The rear balcony west side at first floor has not been amended on any of the submitted plans and this needs to be 1.7m high. For clarity I request the following amended plans:

- first floor plan drawing number 1714-PL1-06 rev L detailing the extent of 1.7m screening to front and rear sides
- second floor plan 1714-PL1-07 revH incorporating the proposed changes
- Updated West and South elevations to include screening at second floor level drawing 1714-PL1-10 rev C.

REV.	DATE	DESCRIPTION
PROJECT 14 COASTAL ROAD EAST PRESTON BN16 1SJ		
DRAWING PROPOSED SECOND FLOOR PLAN		
CLIENT MRS & MR CLARKE		
SCALE 1:50 @ A1 / 1:100 @A3	DRAWN	
DATE JUNE 2017	CHECK	
DRAWING No. 1714- PL1-07	REVISION H	
© copyright retained

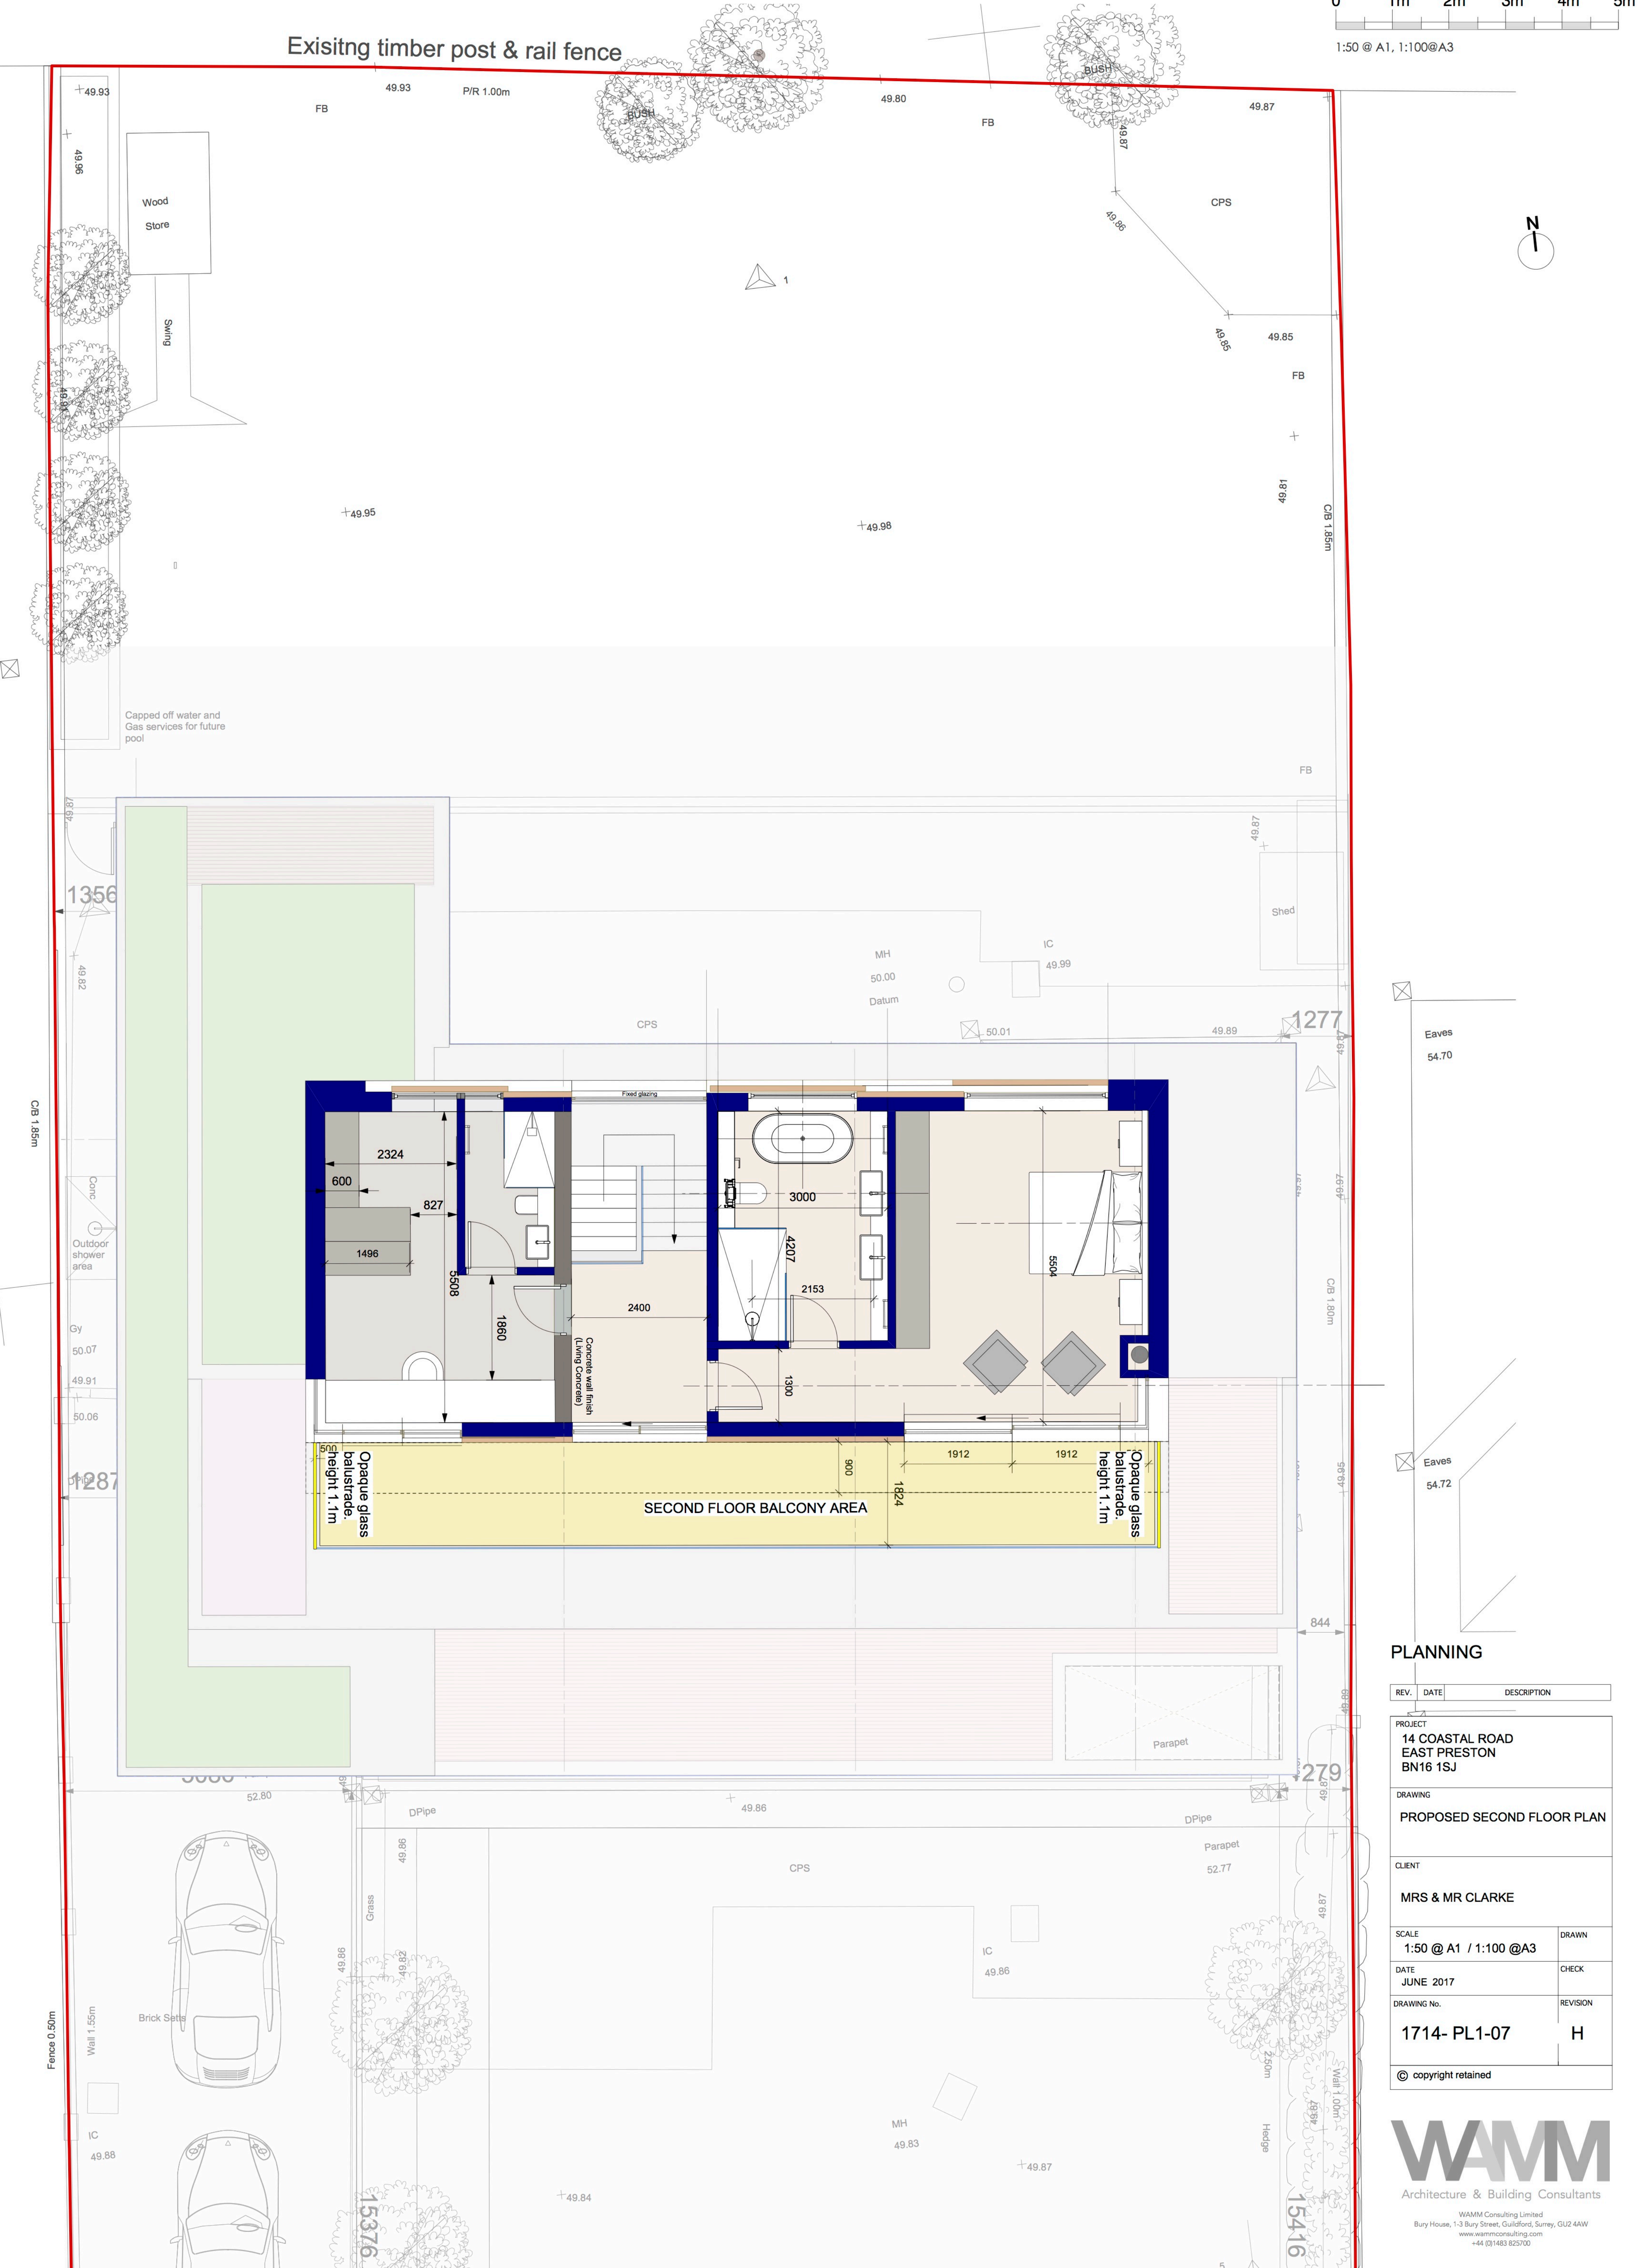
We still consider that even with the inset from the boundary overlooking would be afforded over the adjoining garden to the west. We are referring to the western side only. This is more important than the east given that the front garden of the dwelling to the west is used more by the occupiers who have garaging within their rear garden. The dwelling to the east has more opportunity to use private amenity for sitting out to the rear.

Inset the balcony as shown on the 2nd floor deck plan attached and provide the 1.7m obscure glazed screening on the west elevation only. On the east elevation, obscure glazing to 1.1m.

We can accept the first floor details as submitted, but the second floor will need screening on the side elevation to 1.7m , regardless of the increased distance to the boundary.

REV.	DATE	DESCRIPTION
PROJECT		
14 COASTAL ROAD EAST PRESTON BN16 1SJ		
DRAWING		
PROPOSED WEST & NORTH ELEVATIONS		
CLIENT		
MRS & MR CLARKE		
SCALE		DRAWN
1:50 @ A1 / 1:100 @A3		
DATE		CHECK
FEBRUARY 2020		
DRAWING No.		REVISION
1714- PL1-10		E
© copyright retained

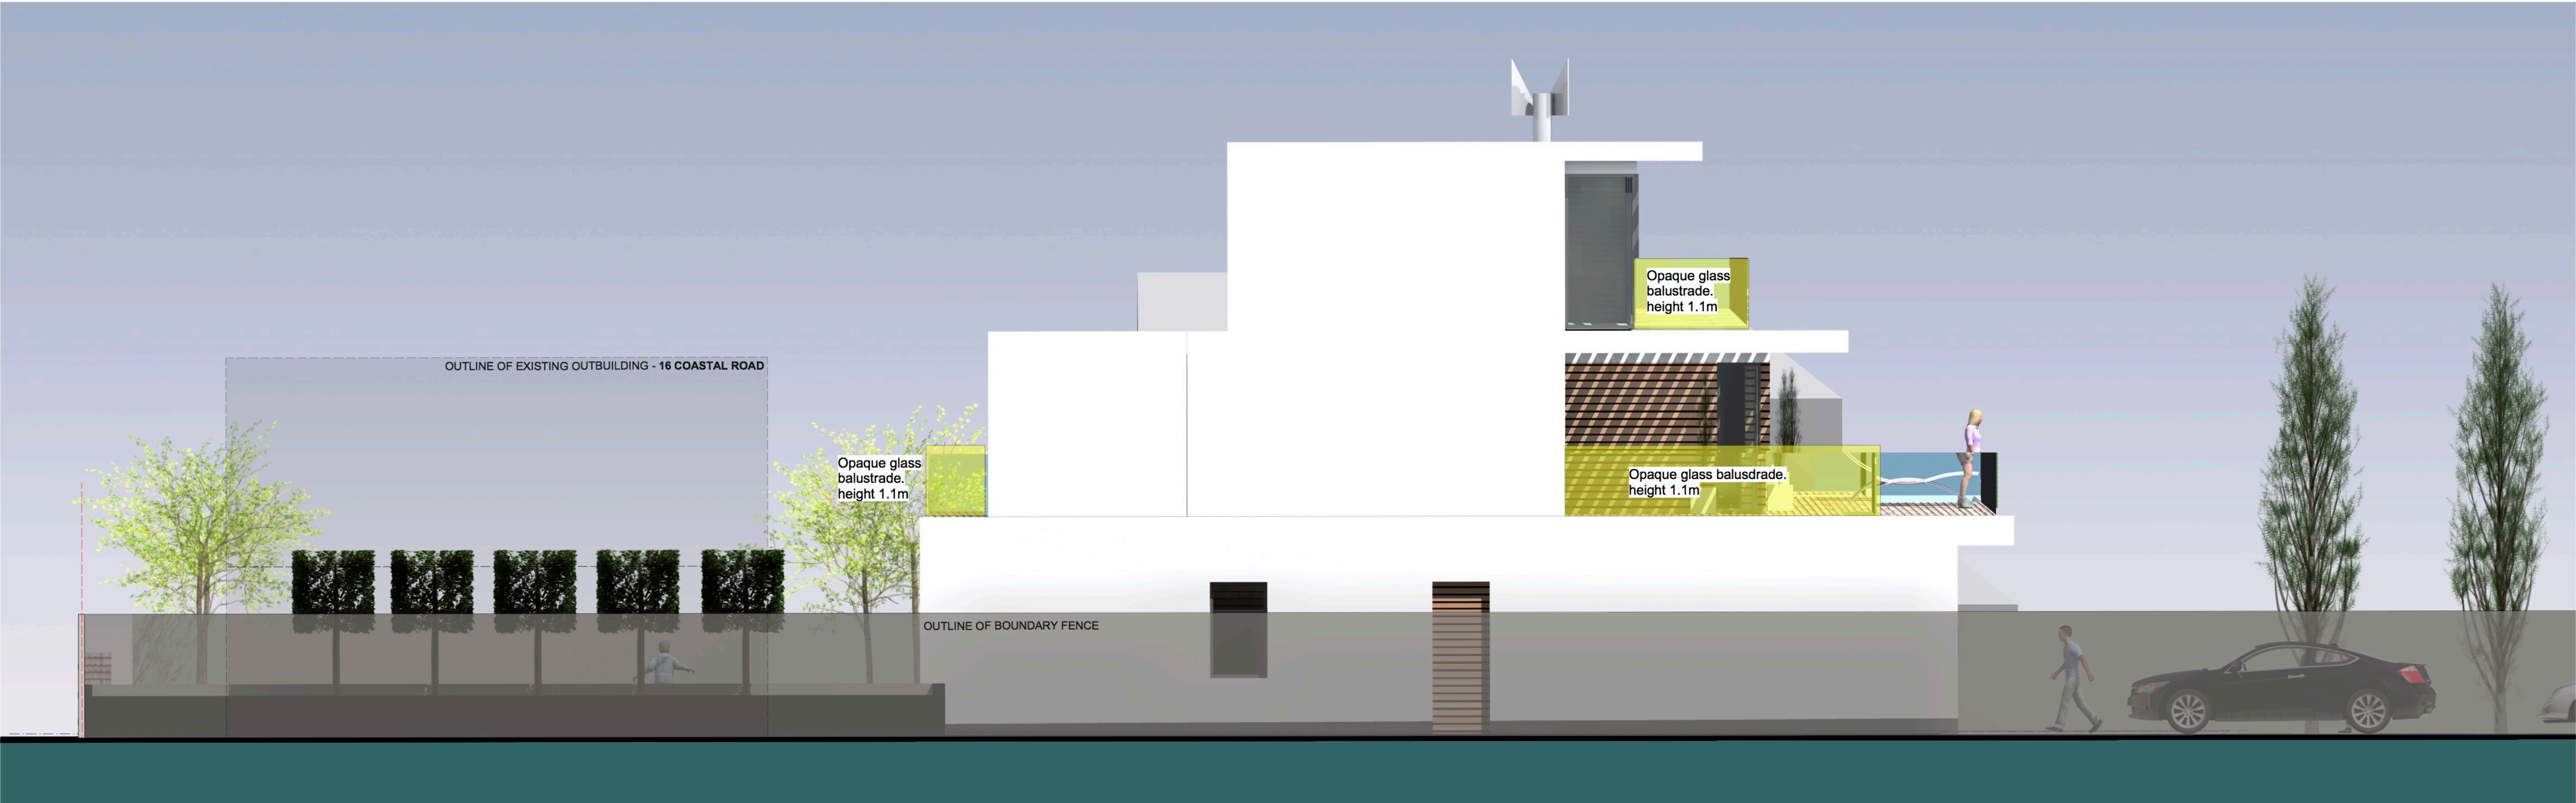
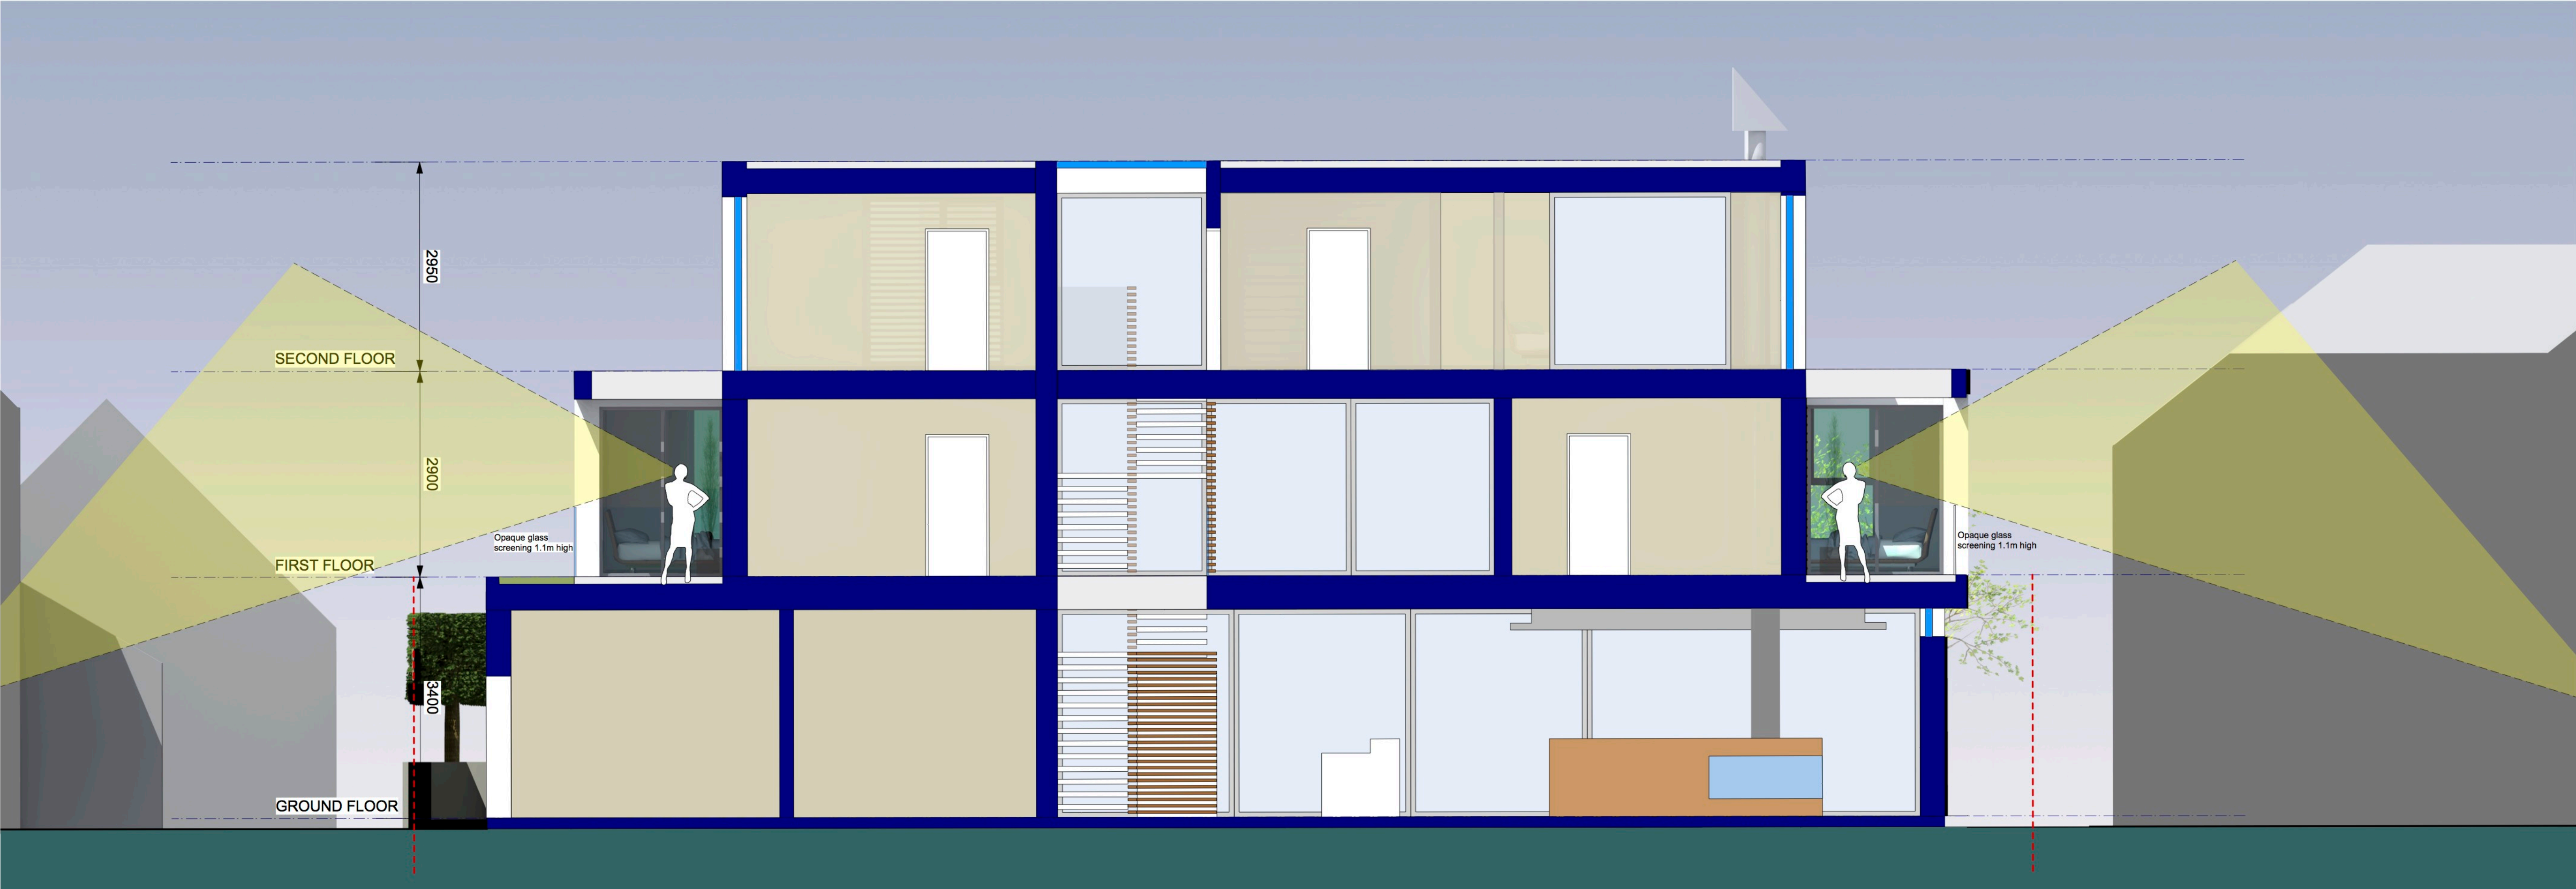
Concerns have been raised by the main contractor that 1.7m high opaque glass balustrade in a coastal location could be difficult to restrain without additional support. We understand that a 1.7m balustrade is required at the end of the decking area at the West elevation on both the first and second floor areas. We propose at first floor that glass or appropriately finished steel structural blades are installed to provide this restraint. This should help to maintain the original aesthetics of the scheme at its extremities where 'flying elements of structure' were proposed. See marked up elevation attached.
